Transport for NSW

TfNSW Reference: SYD21/01554/02

**ENVIRONMENTAL IMPACT STATEMENT (SSD32927319)
POWERHOUSE ULTIMO RENEWAL
500 HARRIS STREET, ULTIMO**

Figure 6-14: Powerhouse Ultimo Renewal- Landscape Plan LA-101 Rev B (Aspect Studios 2022)

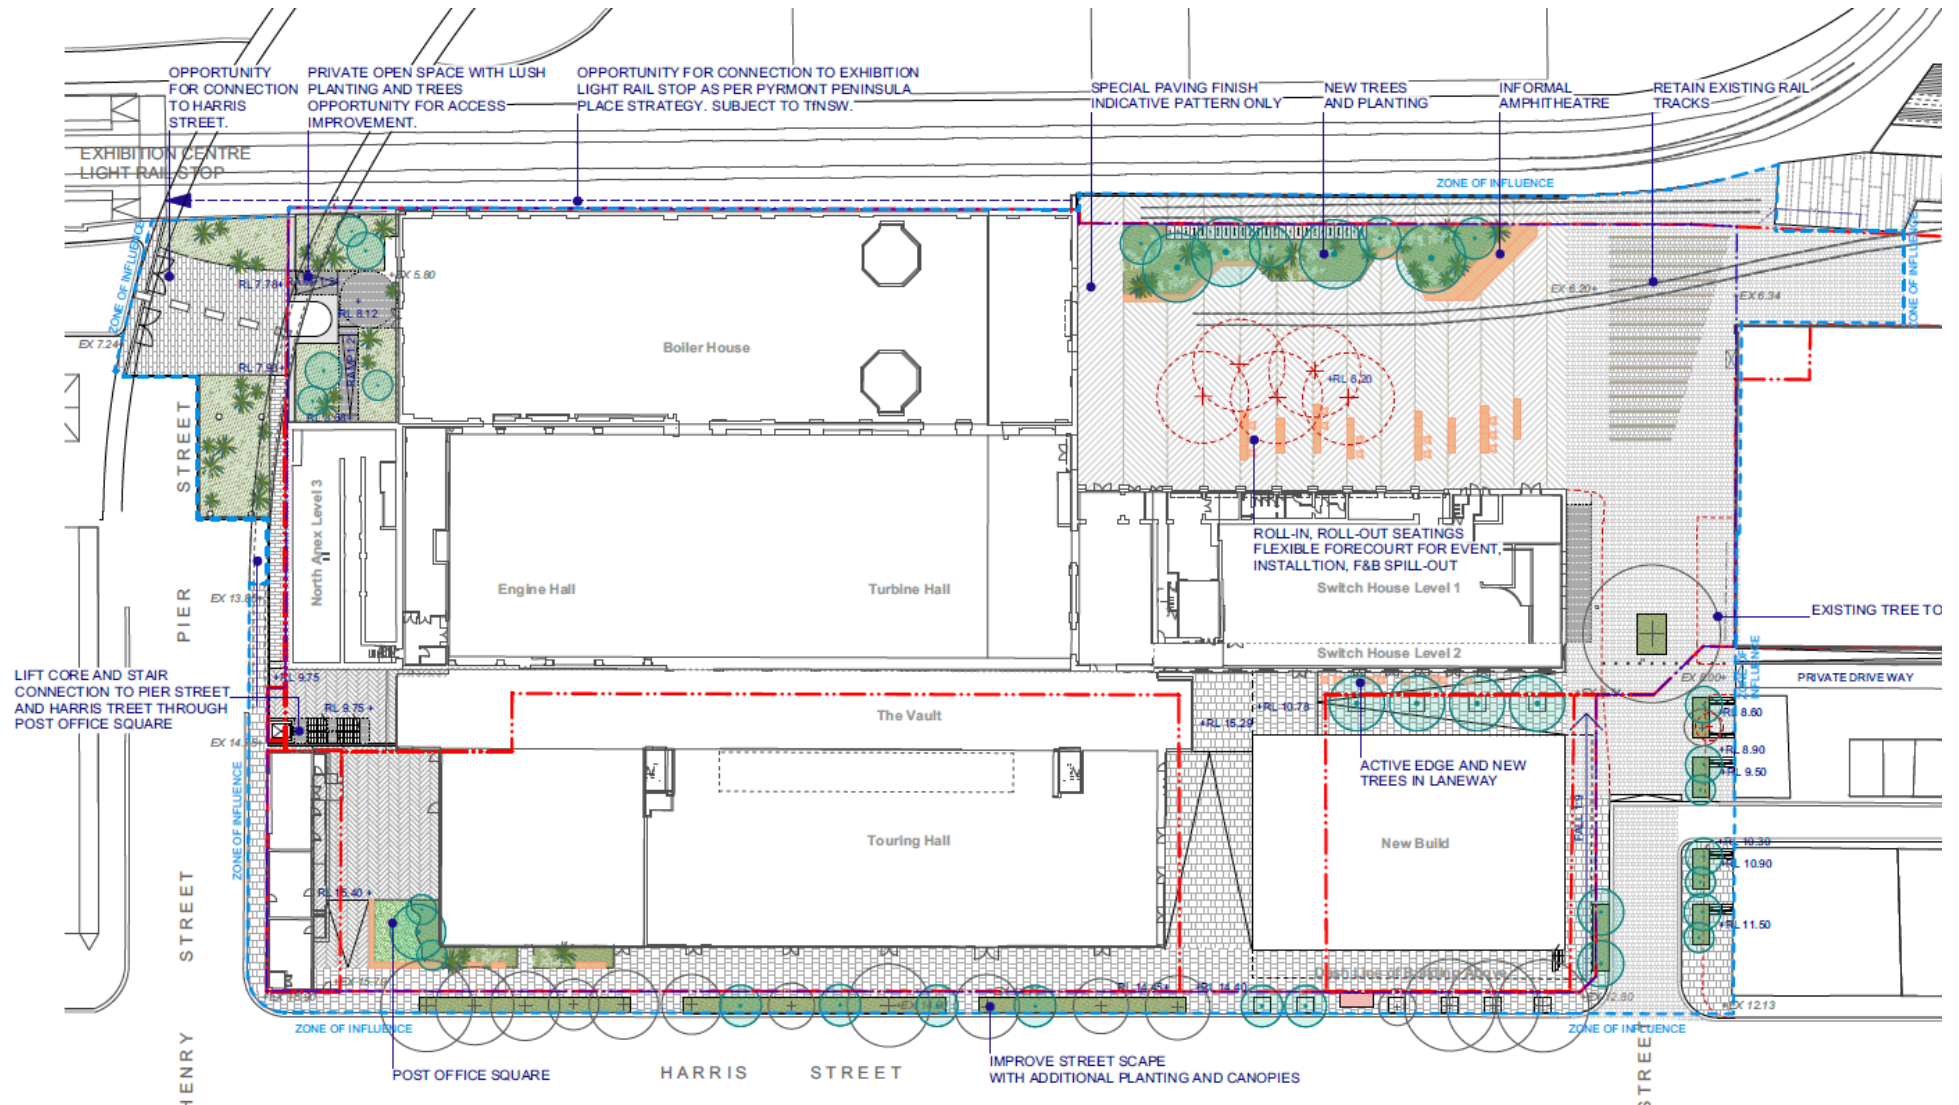
The reference design provided in the Landscape Plans identifies two opportunities for pedestrian connections to the Exhibition Centre Light Rail Stop:

- A pedestrian connection under Pier Street into the northern façade of the Powerhouse site; and
- A pedestrian connection alongside Boiler House, connecting the Goods Line to Pymont Street as per the Pymont Peninsula Place Strategy.

It is unclear if the pedestrian connection alongside Boiler House is proposed to be located within the light rail corridor.

TfNSW supports the provision of new pedestrian connections to the Exhibition Centre Light Rail Stop, however any facilitation of a pedestrian connection with the light rail corridor should be undertaken in consultation with TfNSW.
